From:
Sent: 10 Julv 2024 13:55
To:
Subject: Planning application 2024/91593

This application is for the erection of yet another building on the site of 410/412 Birkby Road.

BLOCK PLAN

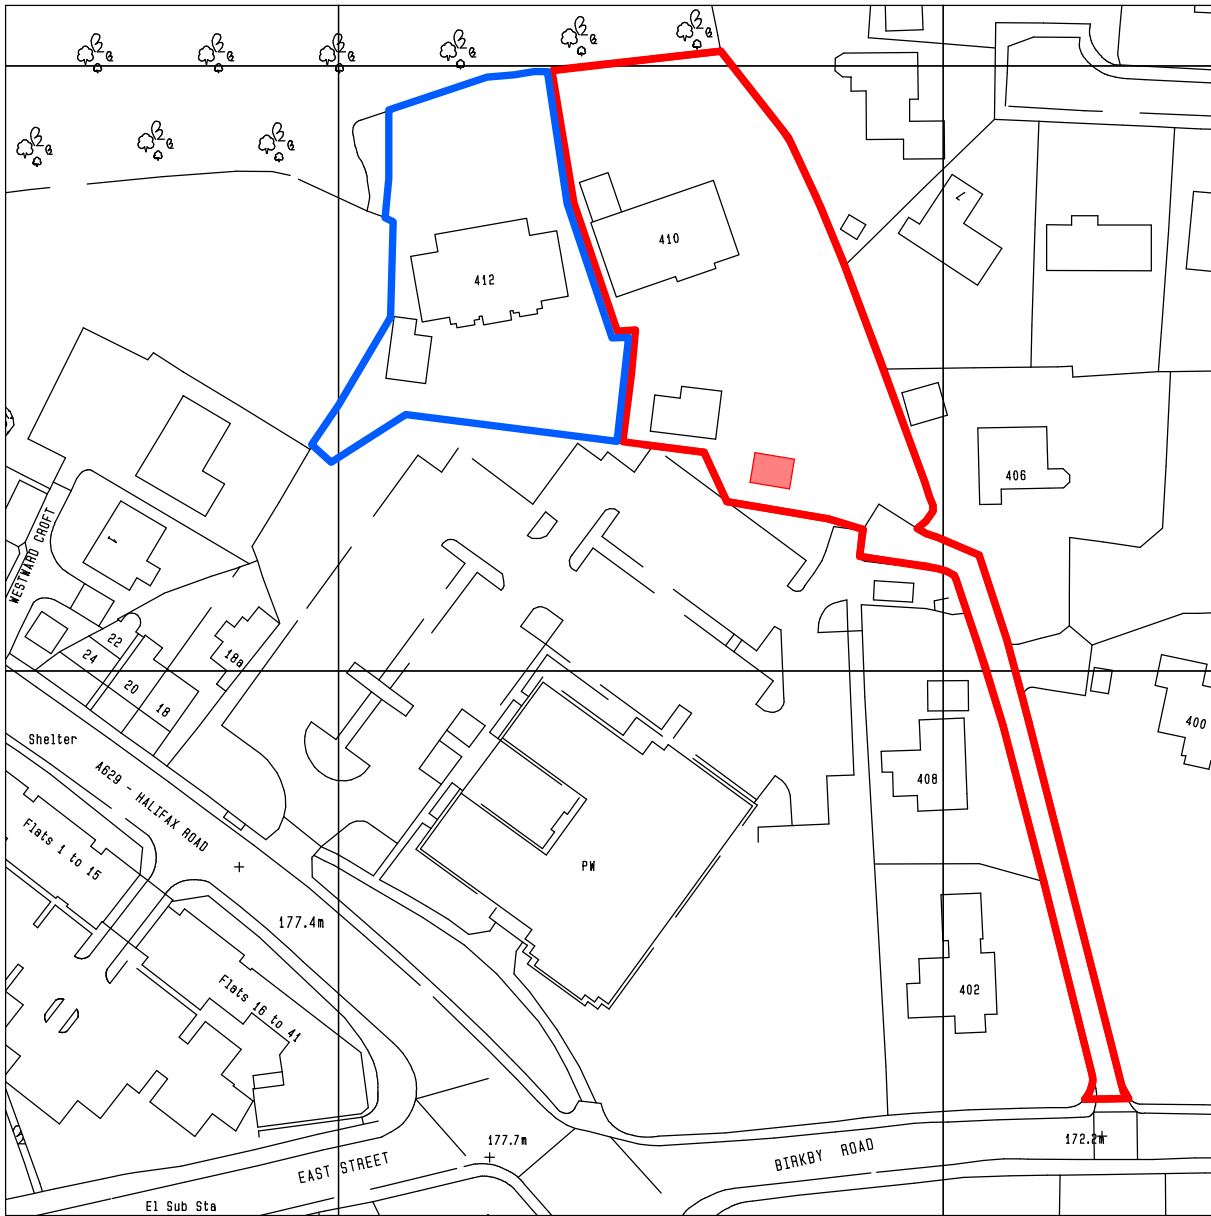
The detached outbuilding in the current application is clearly 100% sited in the red hatched area referred to above. See attached photograph of the red hatched area.

client	MR R.HANDA		
project	PROPOSED STORE 410 BIRKBY ROAD HUDDERSFIELD HD2 2DN		
drawing	PROPOSED SITE PLAN		
revision	notes	date	drawn
scale :	1:200 AT A1	05.23	MG
project no.		drawing no.	revision
2165		01

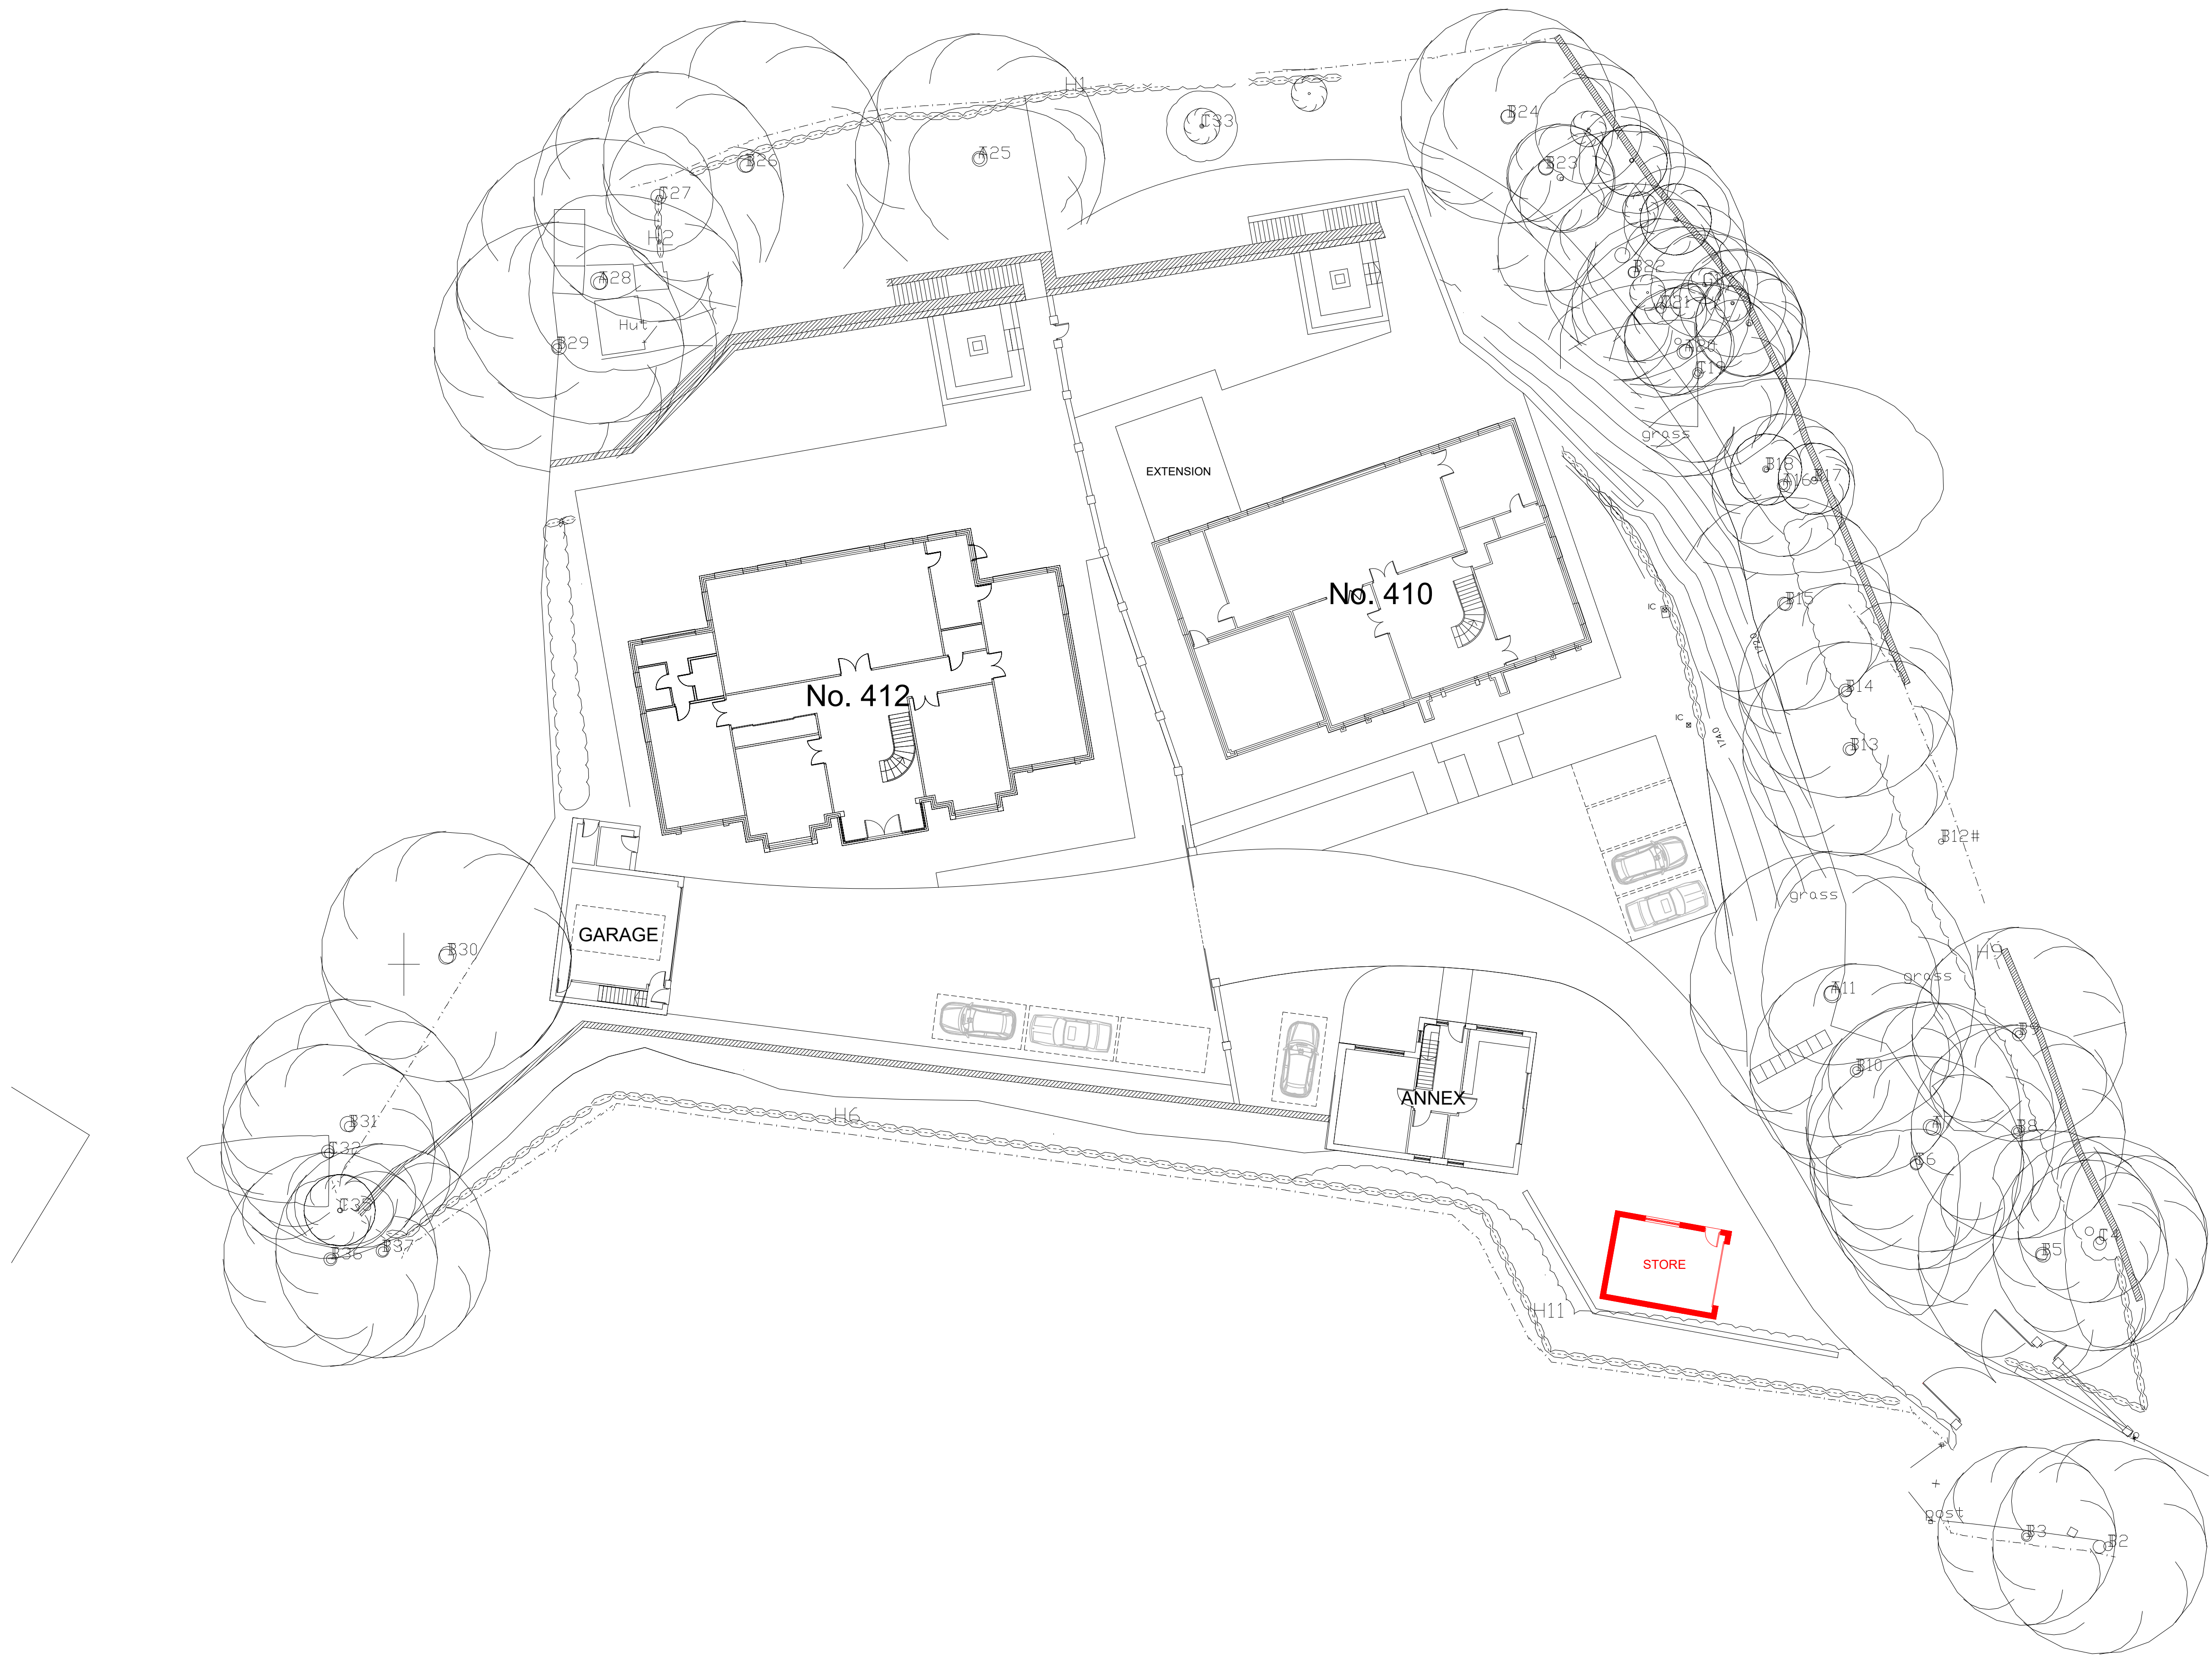
ALSO two other changes to what has been approved on previous applications have now appeared on the proposed site plan and yet have not been formally applied for in this current application:-

1. Hard standing for 4 cars has moved from in front of 410 house and is now shown in what was previously designated a lawned area . It is now directly adjacent to the Tree Protection area on the eastern boundary of the site, possibly encroaching it. To move car parking to this area would mean removing probably the last remaining non-concreted/paved over or built on area on the whole of the flat portion of the 410/412 site, as the site falls away on both the eastern and northern boundaries (very steeply on the northern boundary)

2. To the rear of both 410 and 412 on the northern boundary- again adjacent to the Tree Protection area- there are now 2 'squares' showing by the steps of each. What do these squares signify? Additional buildings?
